Project Name: The Forefront at Thompson's Point Roadway Extension

Project ID: 2017-065

On June 5, 2017 the Planning Authority approved a Level II Site Plan application to extend a private roadway and associated infrastructure for the Forefront at Thompson's Point. The decision is based upon the application, documents and plans as submitted and prepared by Bo Kennedy, PE, of Placemaker Partners, LLC on behalf of Forefront Partners I, LP. The proposal was reviewed for conformance with the standards of Portland's site plan ordinance. The scope of work includes approximately 450 lf, and 7,500 sf, of paving area in support of the previously approved (January 12, 2016) Sectional 2 Subdivision Plan, extending the roadway from the end of the previously approved (January 12, 2016) Level III Site Plan associated with the Brick South Event Center to a point in front of the Depot/Pavilion structure. The roadway extension includes provisions for water, sewer, drainage and communications infrastructure, as well as lighting, landscaping and pedestrian safety improvements. This application serves as partial fulfillment of the approved Master Development Plan for The Forefront at Thompson's Point

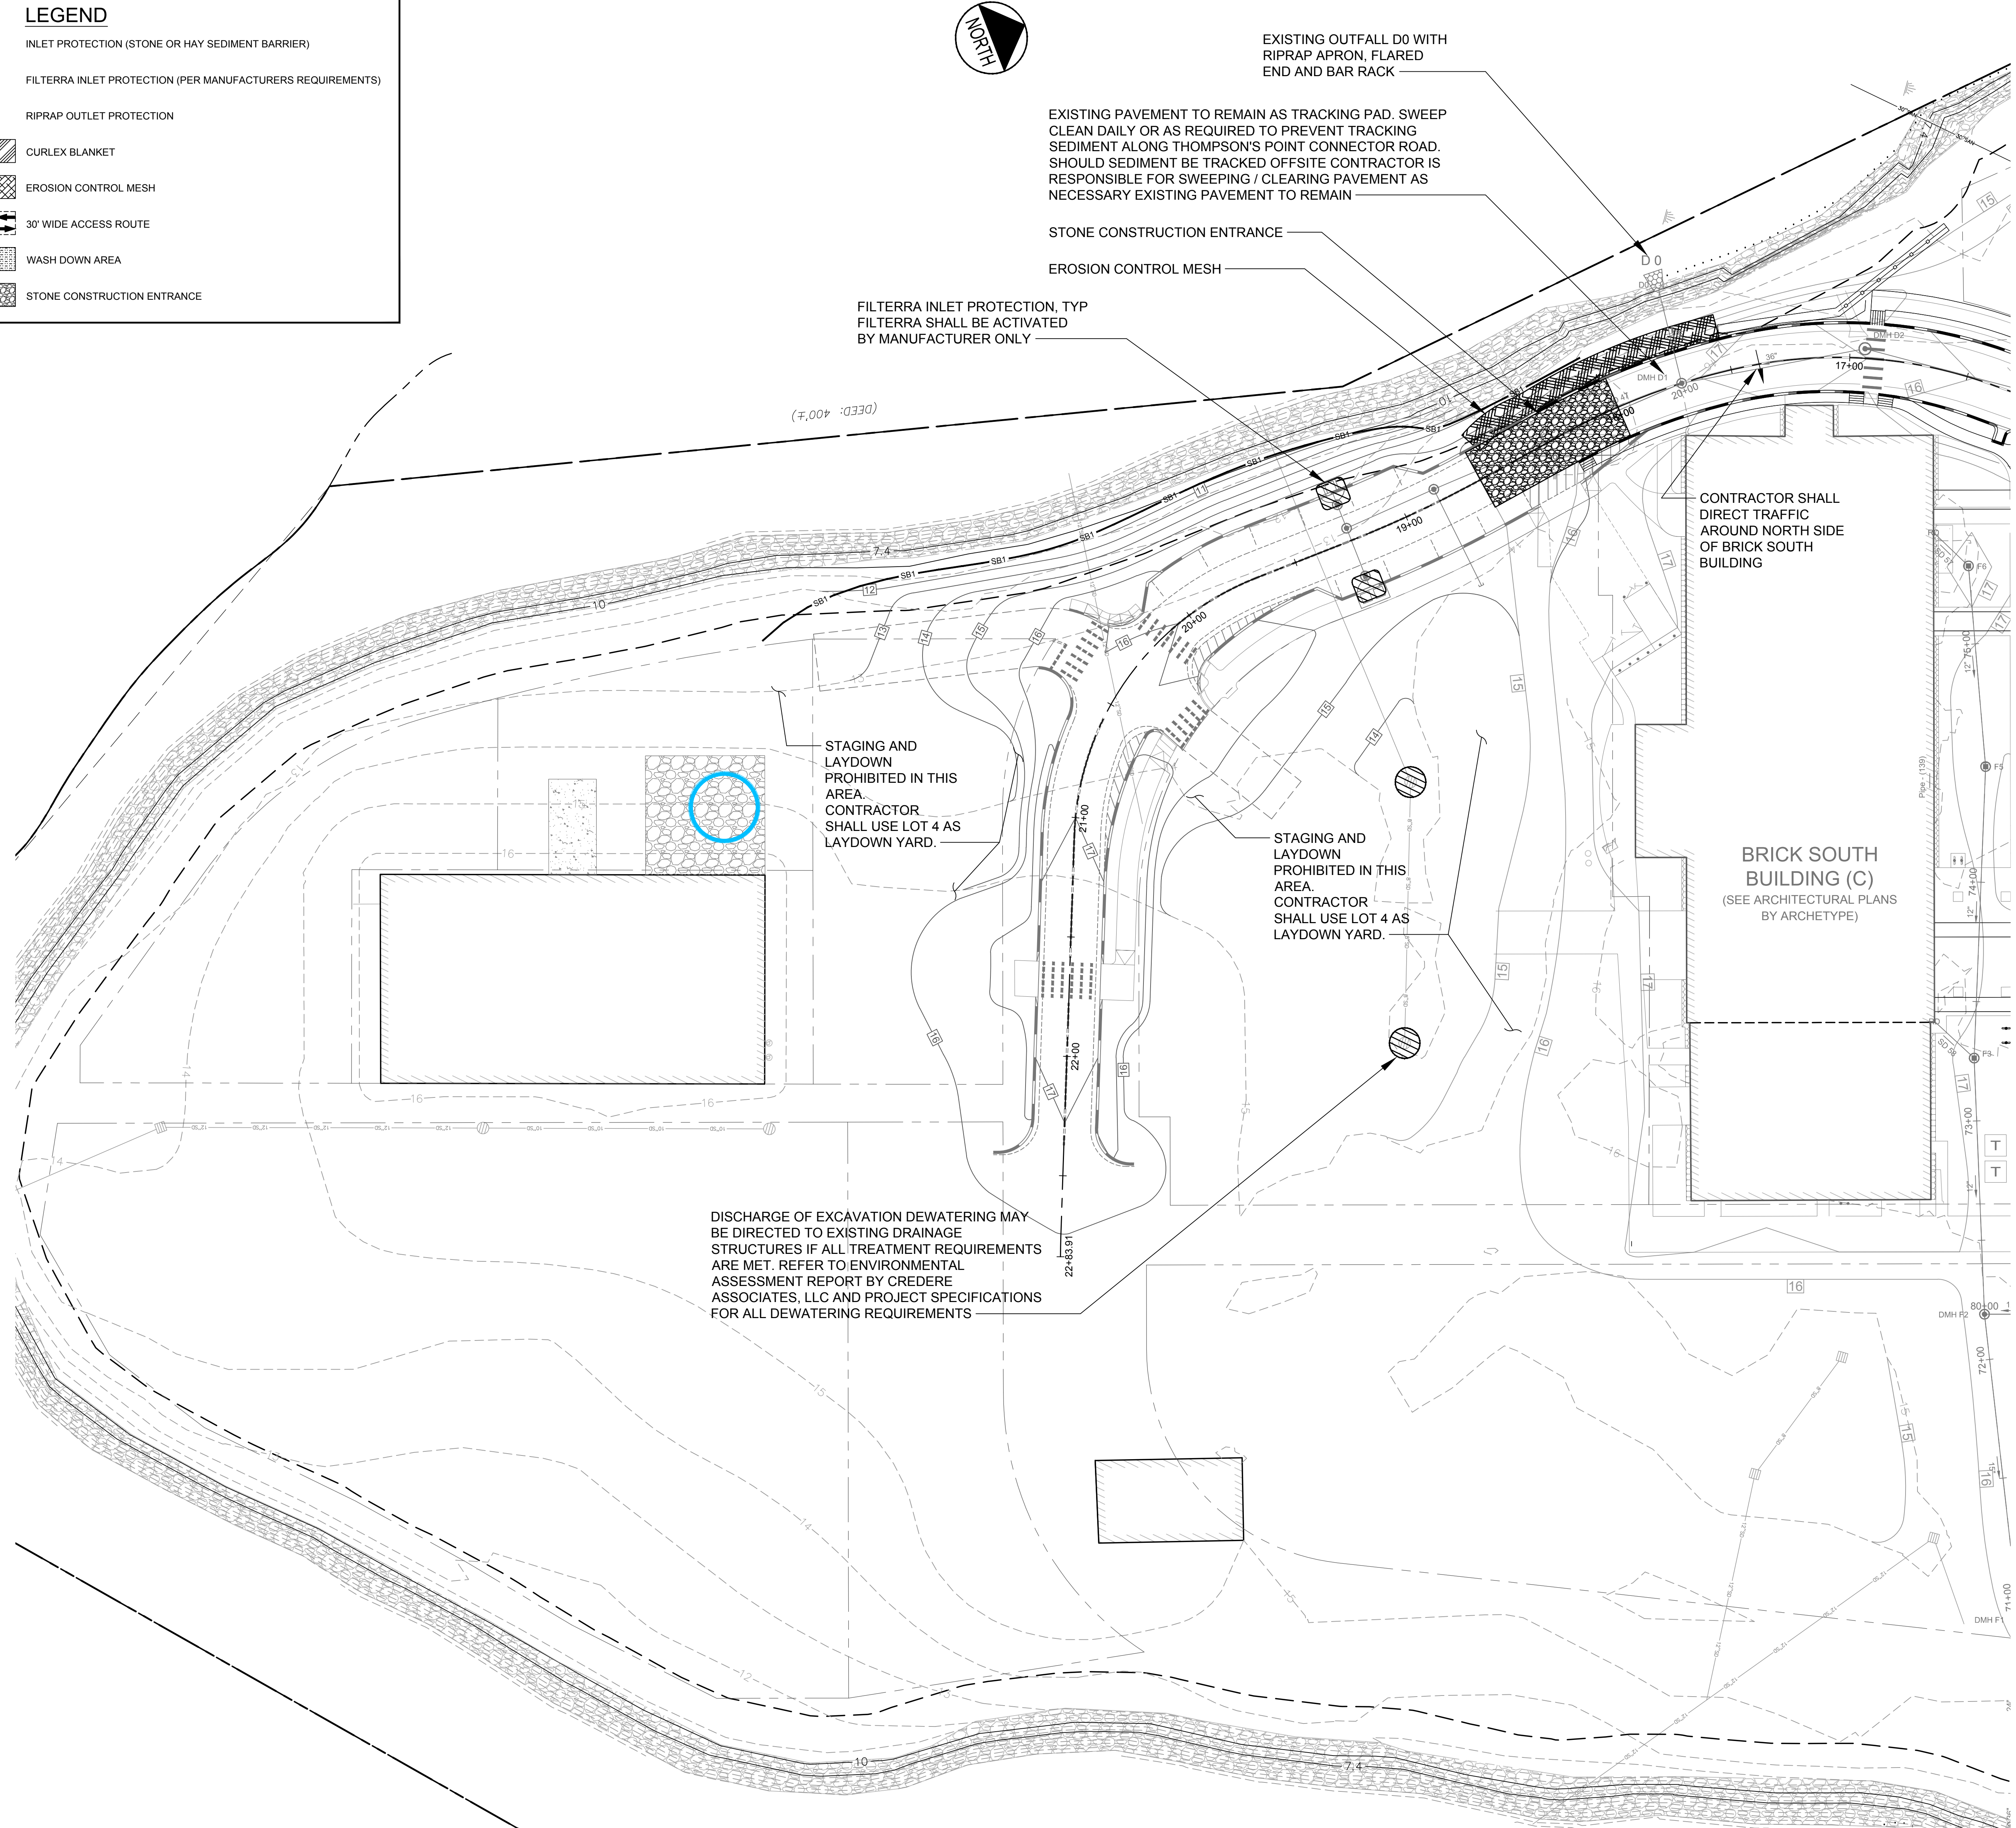
1. The area of painted 4ft chevrons should be replaced by mountable concrete or stamped pavement.
2. The northern-most parking space, on the western side of road (adjacent to station 19+00) should be removed from the final plan.
3. More information is required for construction management – please provide a construction schedule, primary contact person information, and a plan showing temporary routes, areas for equipment staging, and areas for emergency response access in addition to a description of how construction will be managed on event days.
4. Additional Site Plan and/or Subdivision approvals for The Forefront at Thompson's Point may require crosswalk placement as shown on sheet C-3.0 to be relocated, supplemented by additional crosswalks, or other site design elements in support safe pedestrian and vehicular circulation.

- A construction management plan has been provided and the following should be addressed.
 - The plan notes that pedestrians will be detoured around Brick South to destinations on the Point. The applicant should implement improvements, as necessary, to the detour route that meet ADA requirements. This shall include the surface, which shall be “firm and stable” (stone dust is an example of a firm and stable surface).

- The work zone shall be fenced or use of other strategies that will physically prevent pedestrians for accessing the construction area.
 - Prior to any event, City staff shall approve the treatment implemented within the Work Zone.
